Submissions and Amendment Report

**Infill Affordable Housing
138 Maroubra Road, Maroubra
SSD-81426710**

**19 May 2026
240128**

DRAWN BY	SCALE	SHEET SIZE	PRINT DATE
Author	1:100	A1	18/09/2025
DESCRIPTION			5:09:04 PM
GROUND FLOOR PLAN			
PROJECT No	DRAWING No	REVISION	
21_435	DA1.104	V

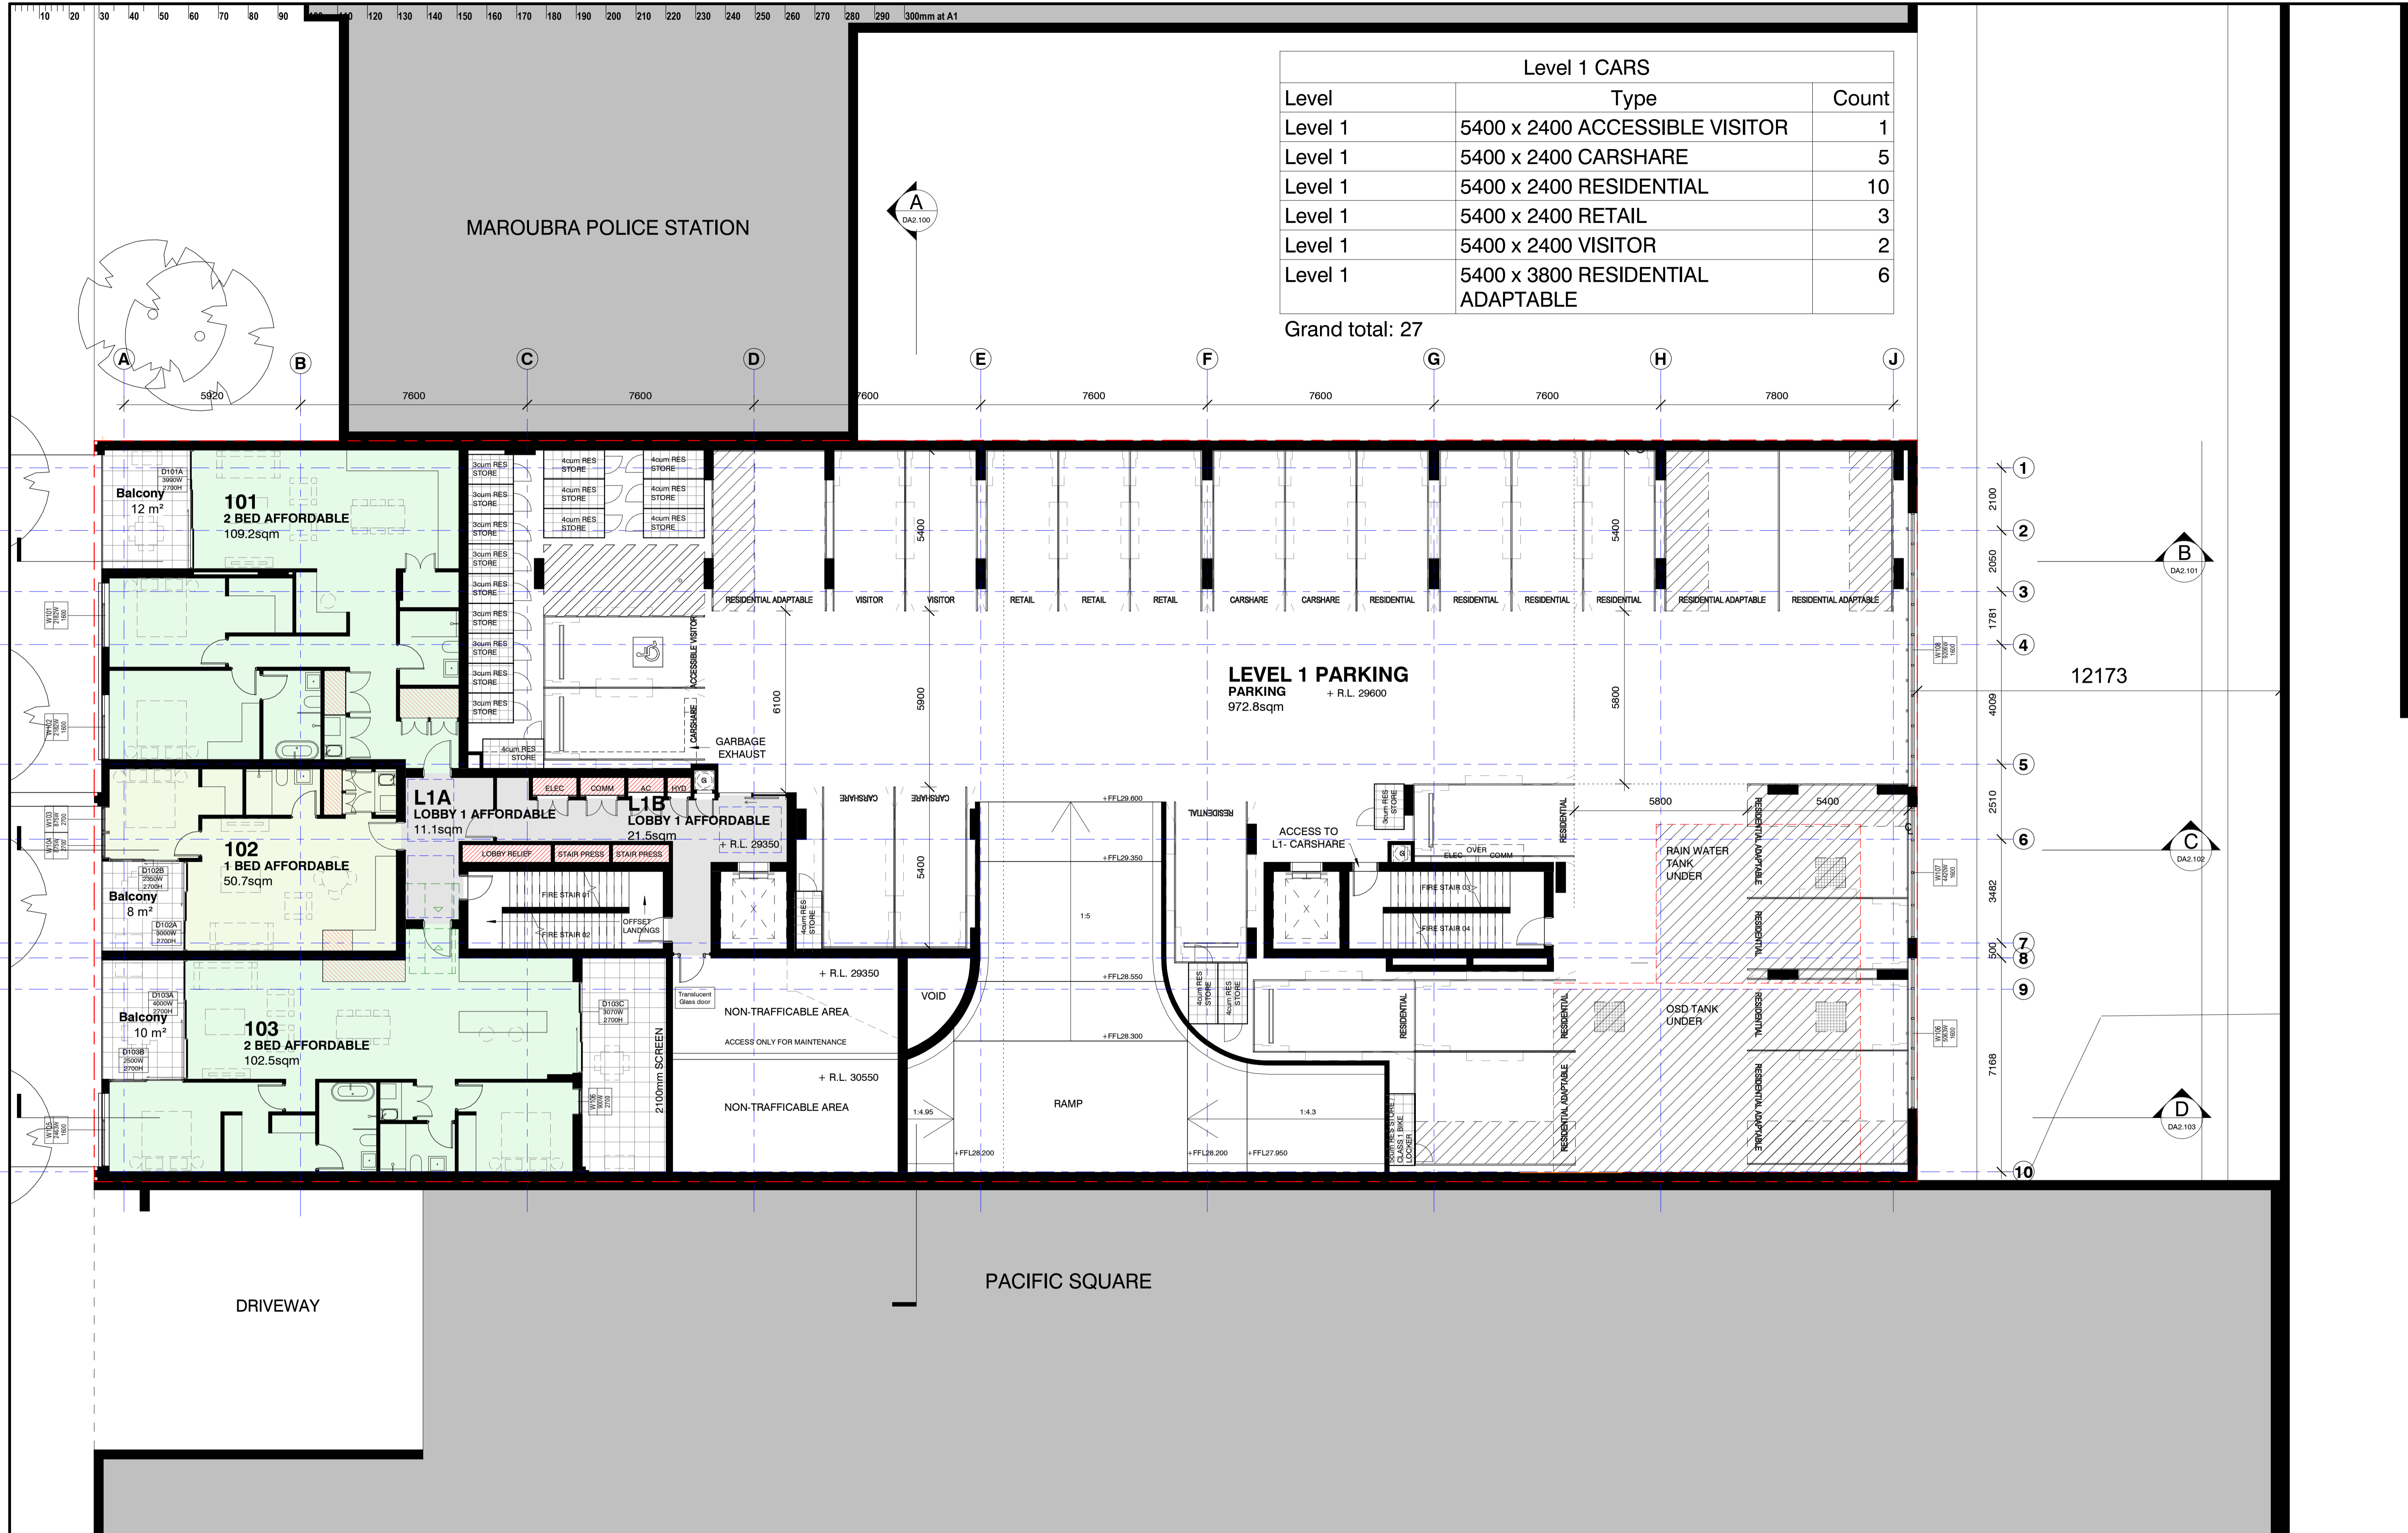
DPHI Advice	Response
<i>The ground floor design should be reviewed and vehicular access point relocated to the rear. The retail tenancy and lobby areas are burdened with narrow and restricted floor area and impacted sightlines. The new vehicular access to Maroubra Road is a poor design outcome and could instead be improved with additional retail tenancy at the ground floor of the proposed shop-top housing development. On the phone you mentioned working on additional information to address technical matters relating to Australian Standards, however the issue relates largely to the presentation of the shop-top housing to the street, the conflict with pedestrian safety and achieving design excellence.</i>	The Applicant has relocated vehicle egress to the rear Piccadilly Place and increased the street frontage of the ground floor retail tenancy along Maroubra Road. The remainder of the Maroubra Road frontage is required to provide pedestrian access from the street, a fire booster and substation (refer Ausgrid advice in Section 2.2.4).

Amendment	Particulars
Removal of vehicle egress to Maroubra Road	- Basement access and egress has been consolidated to Piccadilly Place in response to submissions and at the directive of DPHI. - The pedestrian lobby from Maroubra Road has been relocated to the eastern part of the ground floor and the layout of ground floor amenities improved.
Retail frontage to Maroubra Road increased	- Approximately 3.4m of additional shop front provided to the ground floor retail. - Total area of retail space increased from 263.0 sqm to 269.7 sqm.
Additional privacy and safety measures	- Additional fixed screens and louvres to west and north facing balconies. - Fixed screen to Level 2 communal open space boundary to childcare centre. - Refer to amended Architectural Drawings.
Additional building articulation	Western facade amended to provide greater building articulation.

DRAWN BY	SCALE	SHEET SIZE	PRINT DATE
Author	1:100	A1	18/09/2025
DESCRIPTION			REVISION
WEST ELEVATION			5:15:36 PM
PROJECT No	DRAWING No	REVISION	
21_435	DA2.203	N

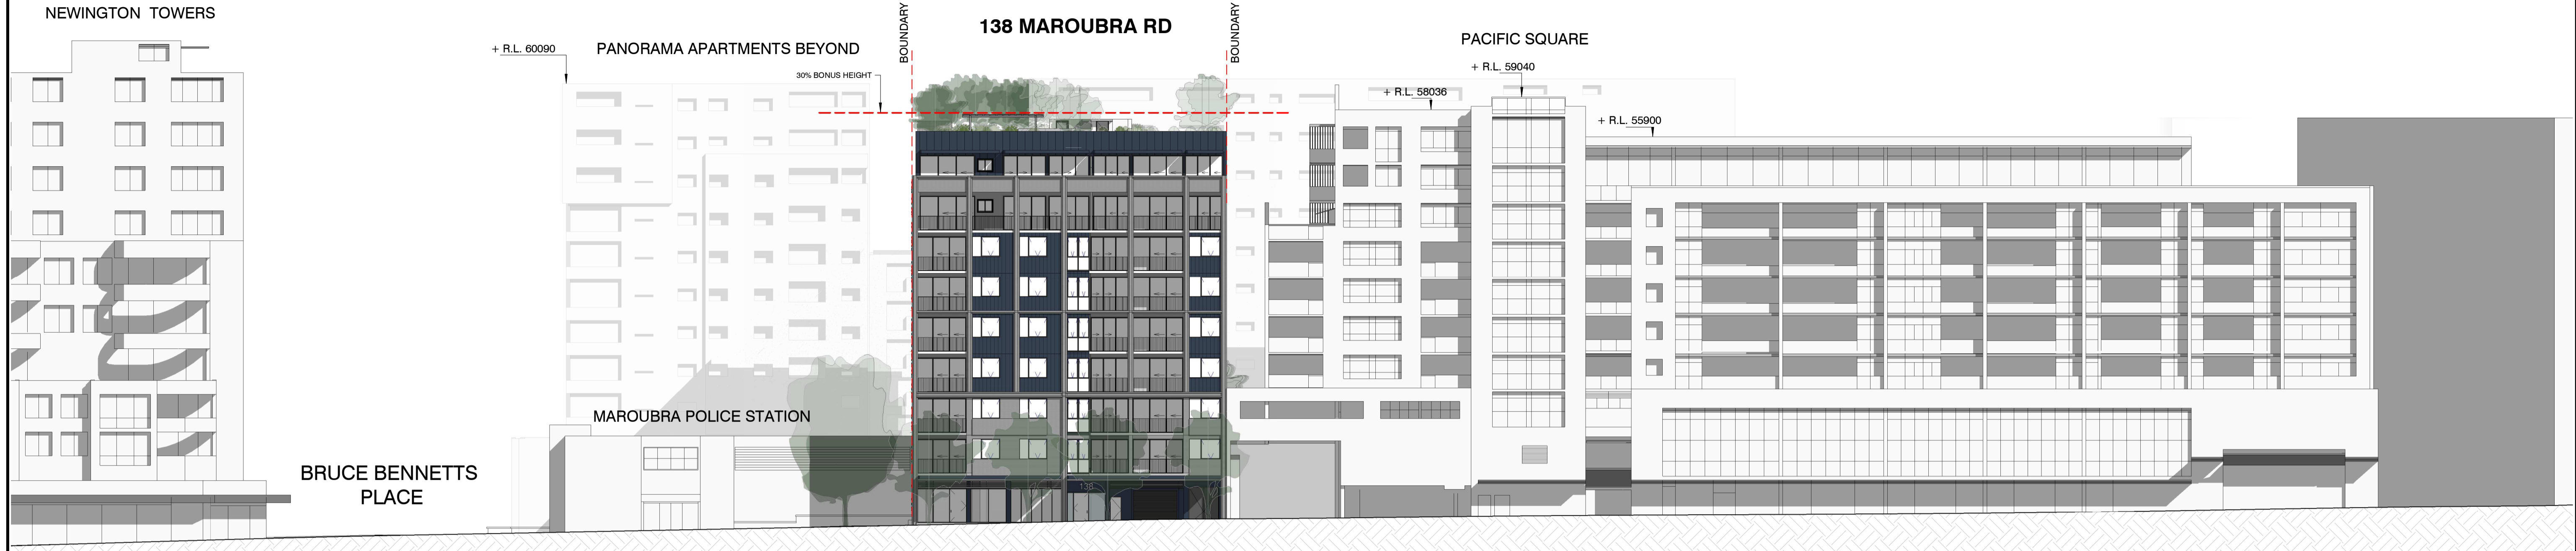
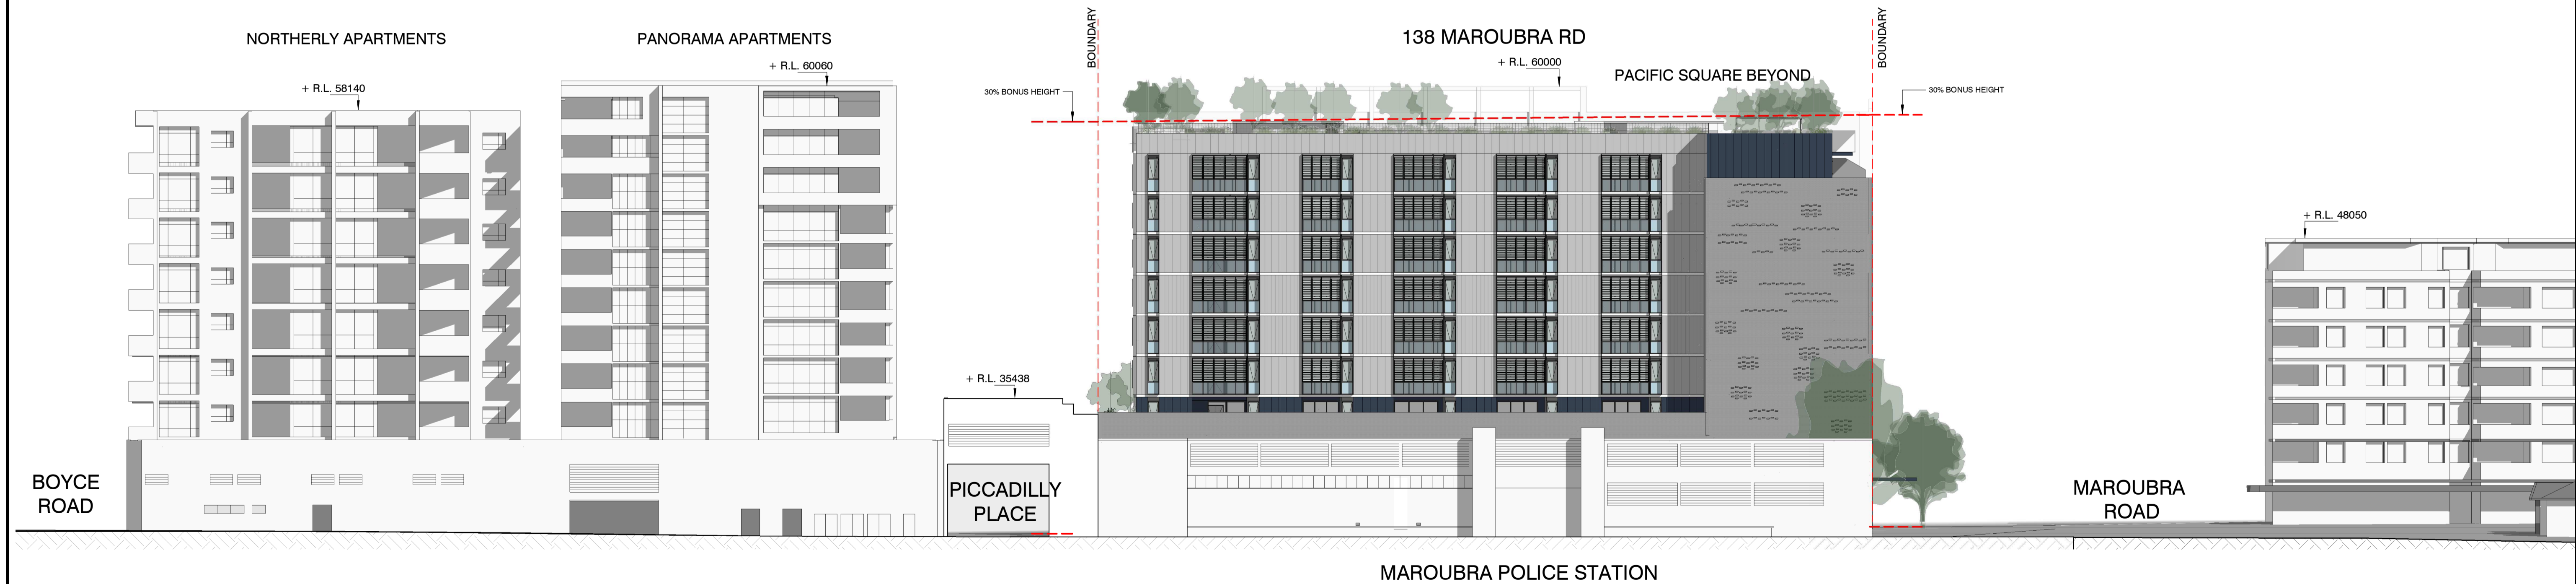
<i>Building design improvements to the side elevations, including the introduction of a central building inset, should be included. As discussed, this is one way of responding to the extensive length and lack of articulation to the side elevations and would assist with reducing the perceived bulk and scale of the development. A building inset to break up the building designed around the two lobby cores provides a visual distinction and relief to the building, and will assist with addressing the requirements of design excellence.</i> <i>Whilst The Department has indicated these improvements would be beneficial applied to both side elevations, the western elevation should be targeted as the primary area for improvement. The Department can consider potentially applying the improvements under (2) above to the western elevation only. Any design amendments and resulting and/or proposed GFA amendments can be reviewed in draft form.</i>	Additional building articulation and use of materials have been provided to the side elevations, in particular the western elevation, to reduce the perceived bulk and scale of the development. The northern core has also been redesigned to provide visual distinction and to separate the building massing at each core.

The proposed development as amended includes additional privacy measures and fixed louvres to the western elevation to maintain safety and privacy. Vehicle egress is no longer proposed to Maroubra Road and will not impact on police parking in that location. A building management plan can be prepared. As set out in the EIS and Design Report, the proposed development has been designed to ensure that an equitable built form can be delivered on the Police Site in the future.
